Rezoning Transportation Analysis

Petition Number: 2023-164

Date	Description
1-24-24	First Review (JP)
2-21-24	Second Review (JP)

DRAWING NO.: **RZ-01**

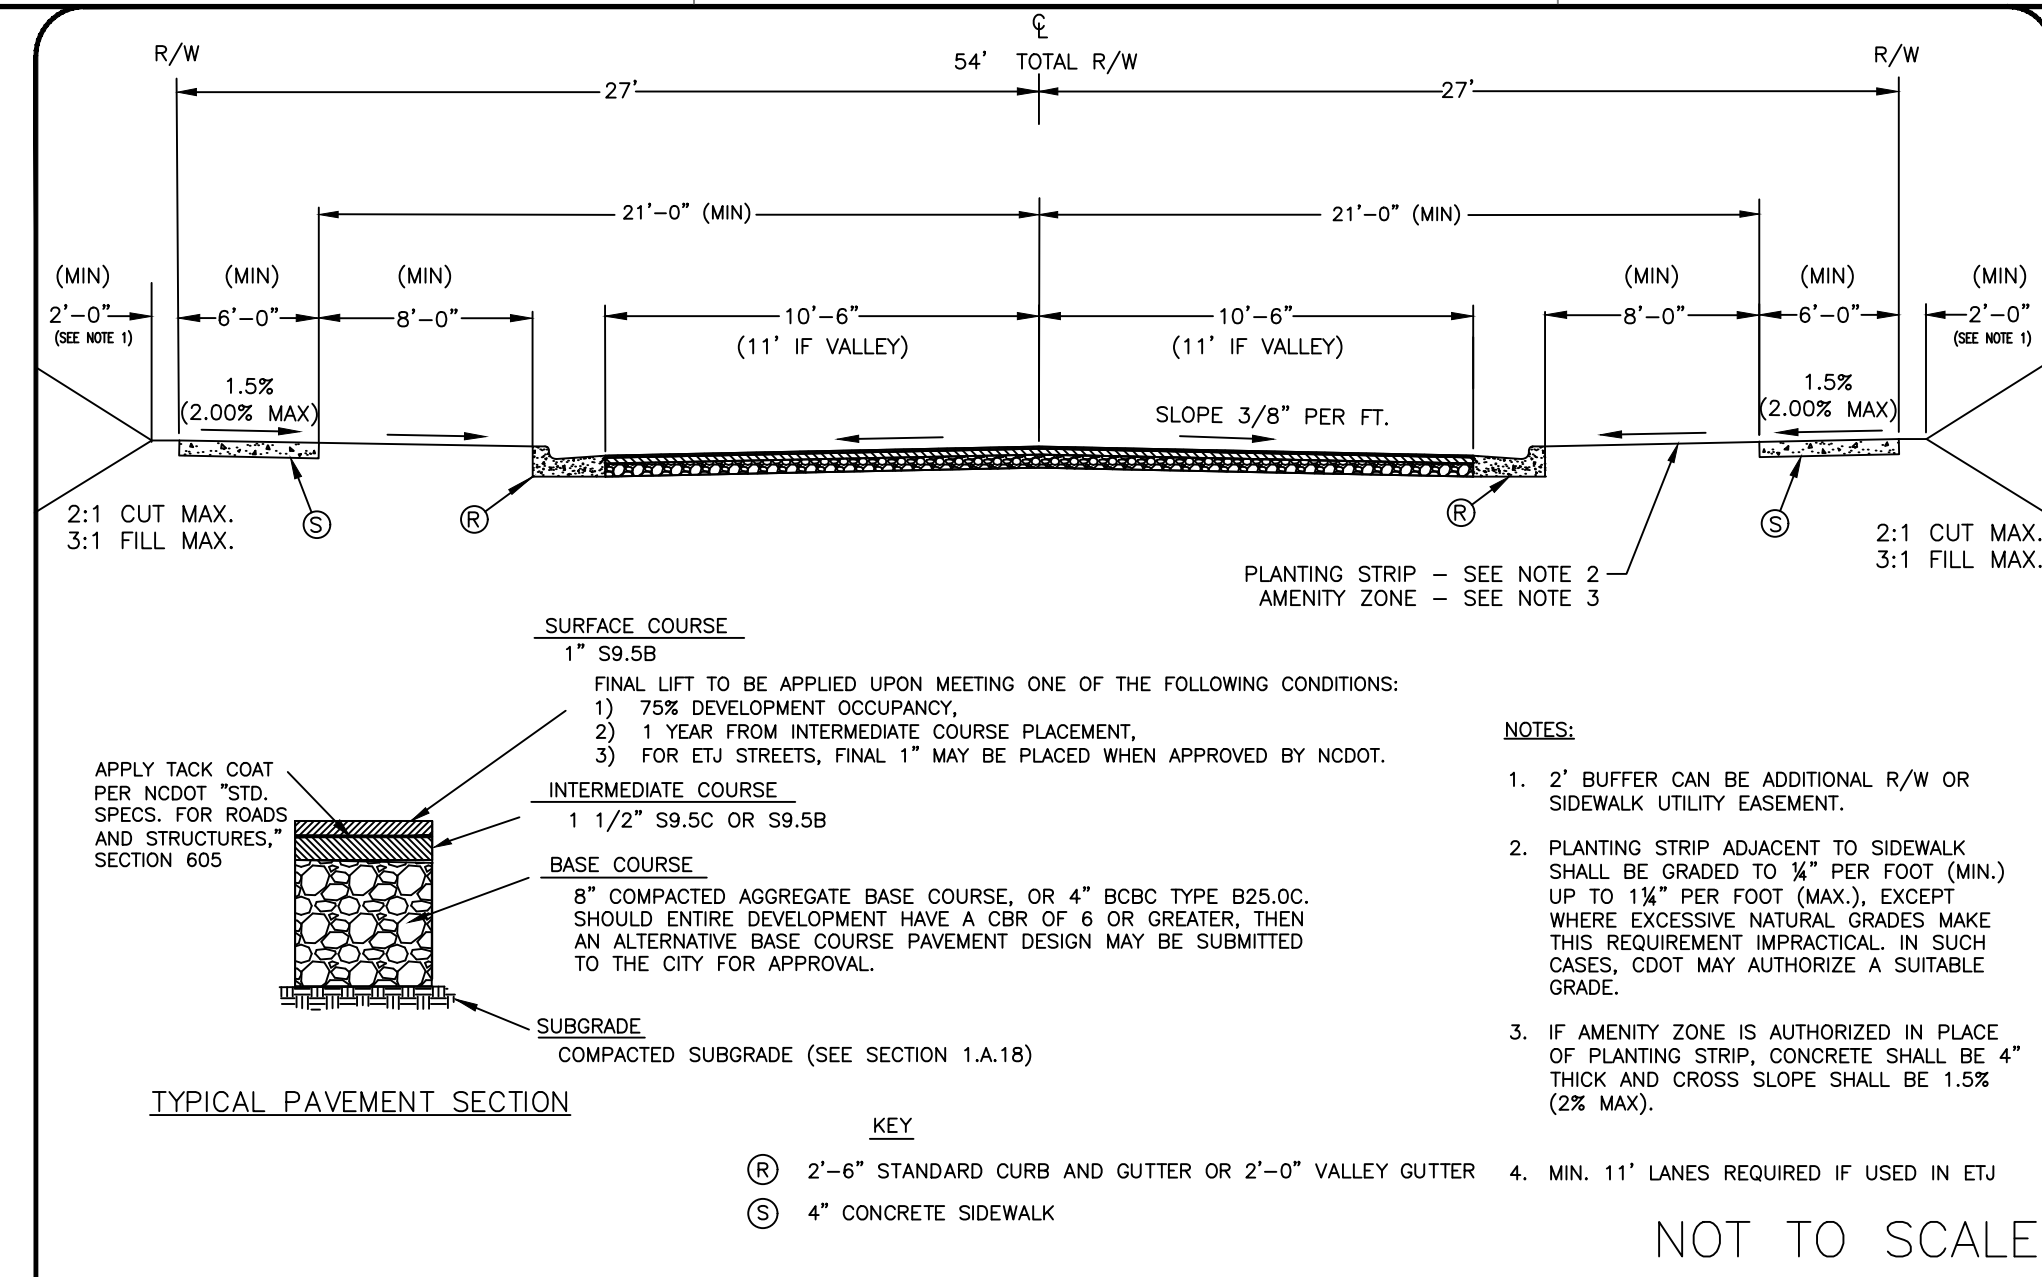
Outstanding Comment 2.21.24: Label and dimension the curb and gutter from the centerline for each road on the site plan.

Clarifying Comment 2.21.24: Complete CTR summary table and include on the revised plan. CTR table link (use Site Data Table – CTR Summary tab):
<https://www.charlottenc.gov/files/sharedassets/city/v/2/growth-and-development/documents/dev-center-fees/resources/udo-site-data-tables-curb-ramps-and-ctr.xlsx>

Clarifying Comment 2.21.24: These must be labeled on the site plan.

Clarifying Comment 2.21.24: Callout concrete median on Steele Creek Road on the inset. Label and dimension the median length.

5. Revise site plan to shift Tryon Street access further from existing driveway.

Clarifying Comment 2.21.24: Show multi-use path on the site plan and call it out. Multi-use path must be in the right-of-way, revise conditional note.

8. **New Comment 2.21.24:** ROW should not be terminating in the middle of the road. Continue the ROW to the end of the street, capturing the street stubs.

Clarifying Comment 2.21.24: Revise site plan to call out the public access easement. Use a different line type for easement versus ROW.
